December 11, 2013

RE: Munjoy Heights

Portland Trails would like to take this opportunity to offer our comments on the proposed Munjoy Heights development. Portland Trails' staff have met on several occasions with the development team and City staff to address the trail connections and overall pedestrian experience, and while we still have a few questions and concerns, we continue to be pleased with the direction the proposal has taken since the first plans.

DRAWING NO.
C-10

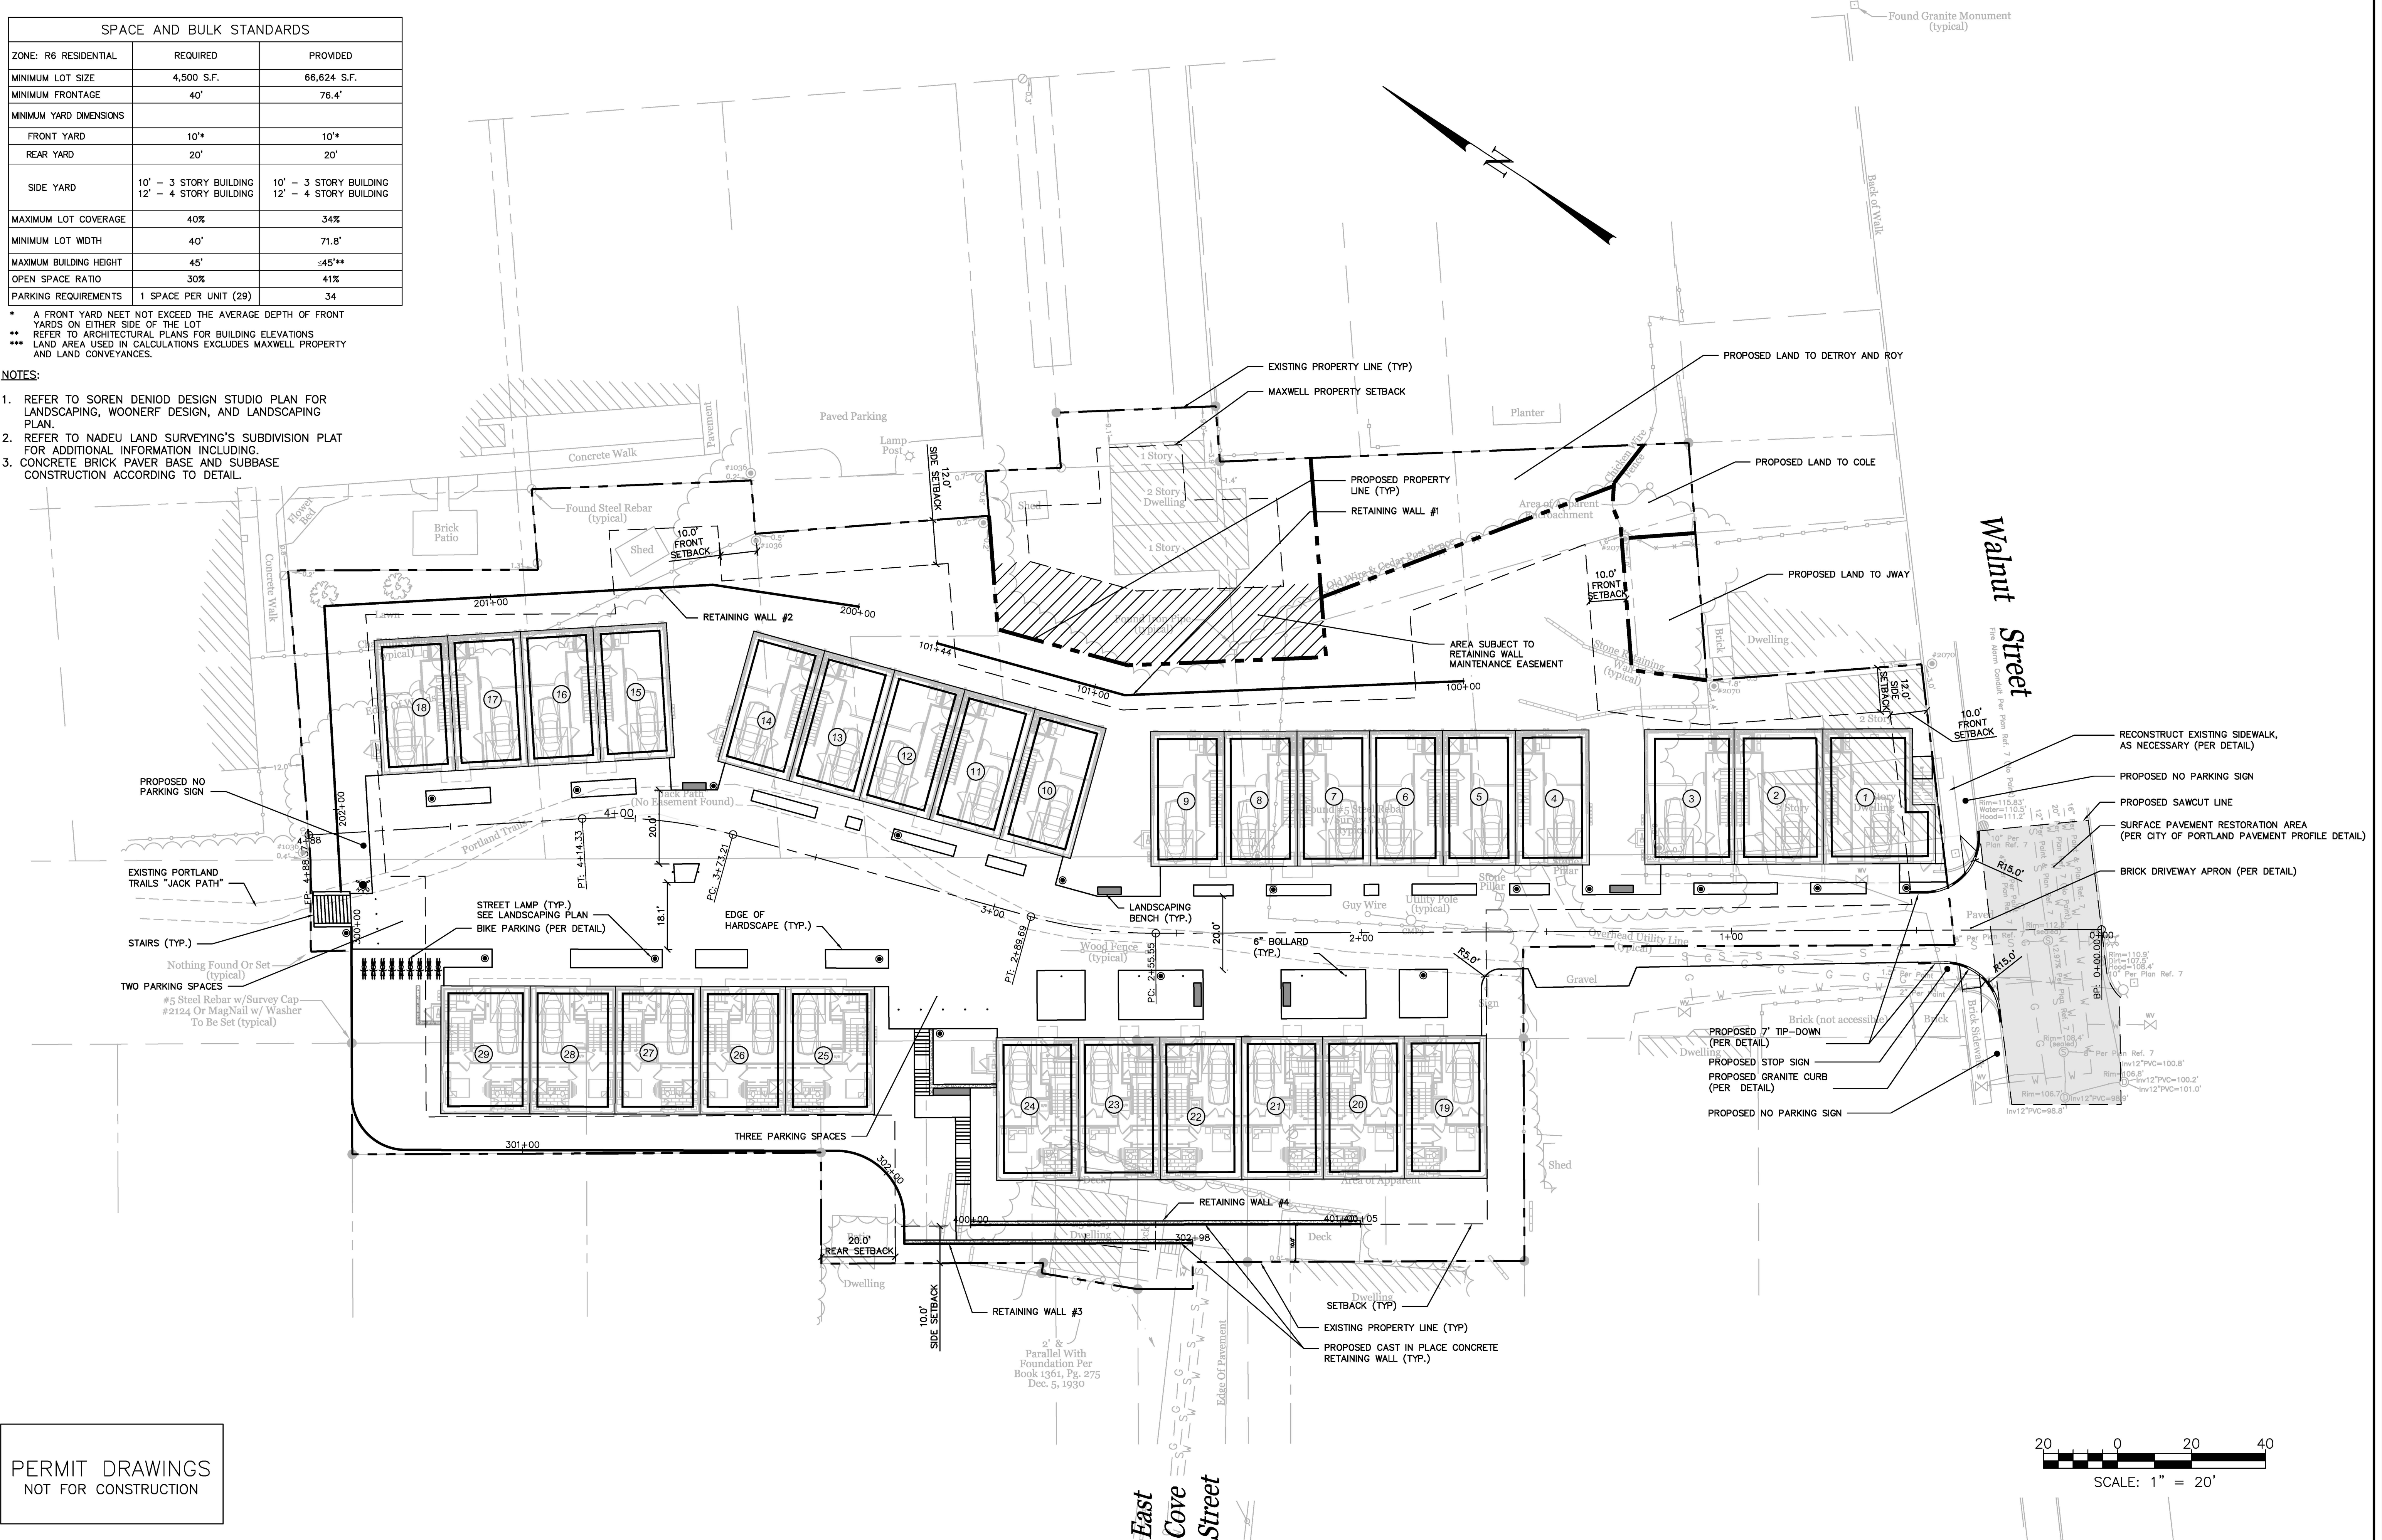
- Trail 'nodes' - We remain concerned that the two locations designated as 'guest parking' are also trail heads. These locations ('nodes') should be visible and inviting, and serve as natural meeting points which help transition between the public and private realms. It is important that they not be consistently obstructed by parked cars. While this is a constrained site, we are optimistic that there is a design or operational solution, and hope to work further with the developer in this regard. Any guidance the Planning Board can provide would be welcome as we seek to balance public safety, parking and a positive pedestrian environment.

Hatched area to be extent of Easement #4 for Portland Trails

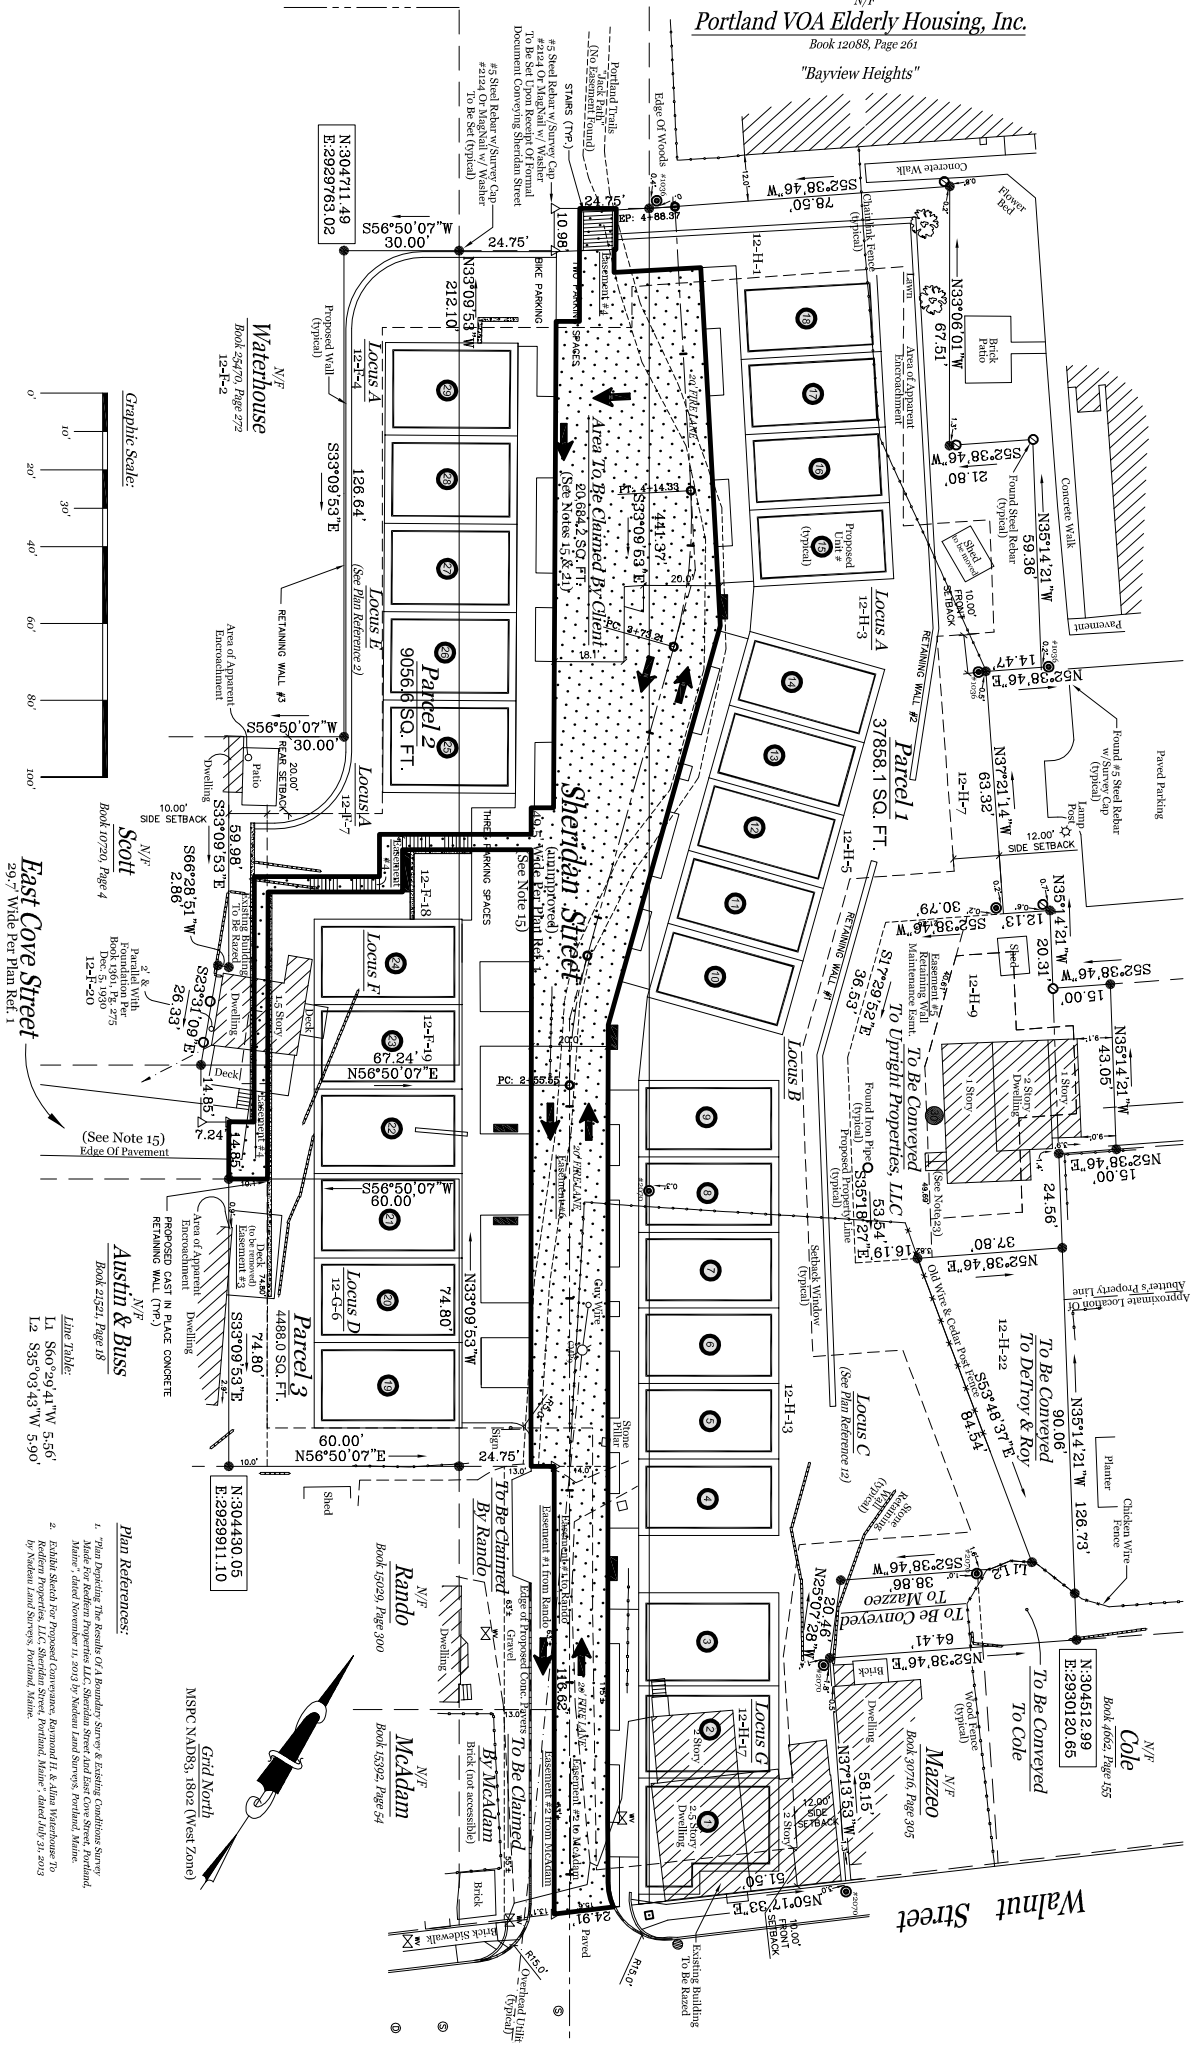
- Public Access Easement - Portland Trails is working with the developer to craft an easement which will allow the public to access and pass through the shared-street portions of the property to connect to the Jack Path and East Cove Street. We are comfortable with the draft easement, but need to finalize the language with the applicant.
